# Botley West Solar Farm

Change Request 2: ES Addendum

September 2025

Document Ref: EN010147/APP/16.3

Relocation of the Proposed Substation and Western Panel Removal

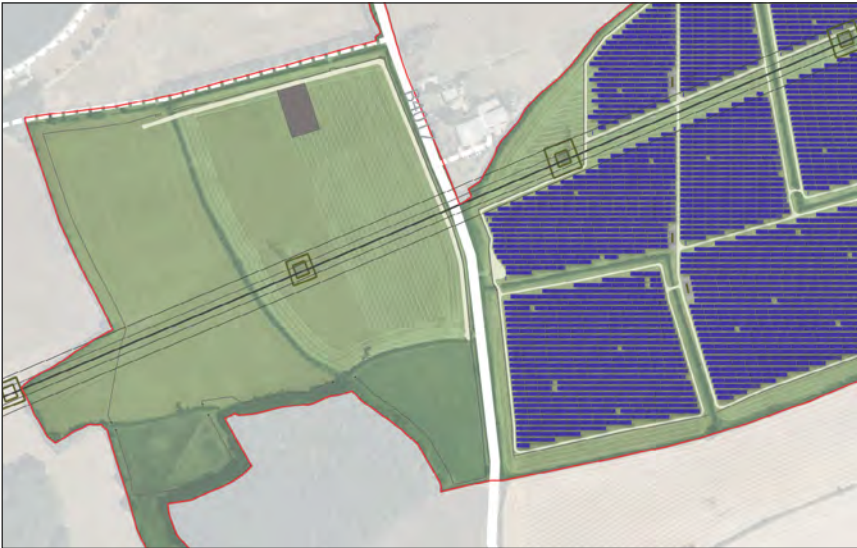
- Relocation of the main Project substation and secondary substation in the event that the National Grid substation is delivered on adjacent land, as shown on Sheet 13b of the Works Plans (updated and submitted alongside this Change Request). The main Project substation and secondary substation would be relocated to the western side of the land parcel within the Order Limits, closer to where the new National Grid substation may be relocated (just beyond the western edge of the Order Limit in this location).

2.5.3 The Applicant proposes a repositioning of the solar array in this area for the scenario where the new National Grid substation is located beyond the Order Limits. Proposed Change 3 would alter the layout of the solar installation but would not change the overall area of solar installation proposed.

2.5.4 The primary purpose of this proposed change would be to allow for a more suitable layout for the delivery of the new National Grid substation on adjacent land to the west, beyond the Order Limits. Relocation of the main Project substation would allow for a shorter, more efficient and more cost-effective cable connection to the National Grid substation. This was recognised by the Examining Authority in the Issue Specific Hearing 1 (on DCO and Strategic Matters) and the Applicant is seeking this change partly in response to that suggestion.
